Arun District Council - Development
Control
Maltravers Road, Littlehampton, BN17
5LF

Reference: PA-0012196/01
Customer reference: BE/67/26/PL
01 October 2026

**Change of use of land to open storage and parking, raising of land levels
(retrospective) and laying of hardstanding, associated landscape works**

Land East Of Heath Place, West Sussex, Bersted, PO22 9SL.

| Drawing No. | 2609HE_003 |

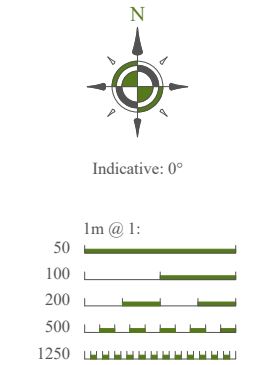
Regarding the retrospective application for land raising in Flood Zone 3b, we would expect the site to be returned fully to the original ground levels prior to land raising. While we acknowledge that the proposed floodplain restoration would provide a betterment over the existing levels, the 184m3 proposed would only equate to 7.2% of the lost floodplain storage being compensated for. Had an application been submitted ahead of the land raising, we would have expected to see any floodplain volumes lost to be fully compensated for.

To overcome our objection, the applicant should restore the site ground levels to the original levels or provide adequate level for level floodplain compensation up to the design flood event including climate change to offset the loss of storage through land raising. Level for level compensation should be located as near as possible to where the loss of flood storage has occurred, to ensure the floodplain remains hydraulically linked. The development site and surrounding areas are largely within Flood Zones 2 and 3. As a result, we do not believe that the requisite floodplain compensation could be provided for the development proposed.
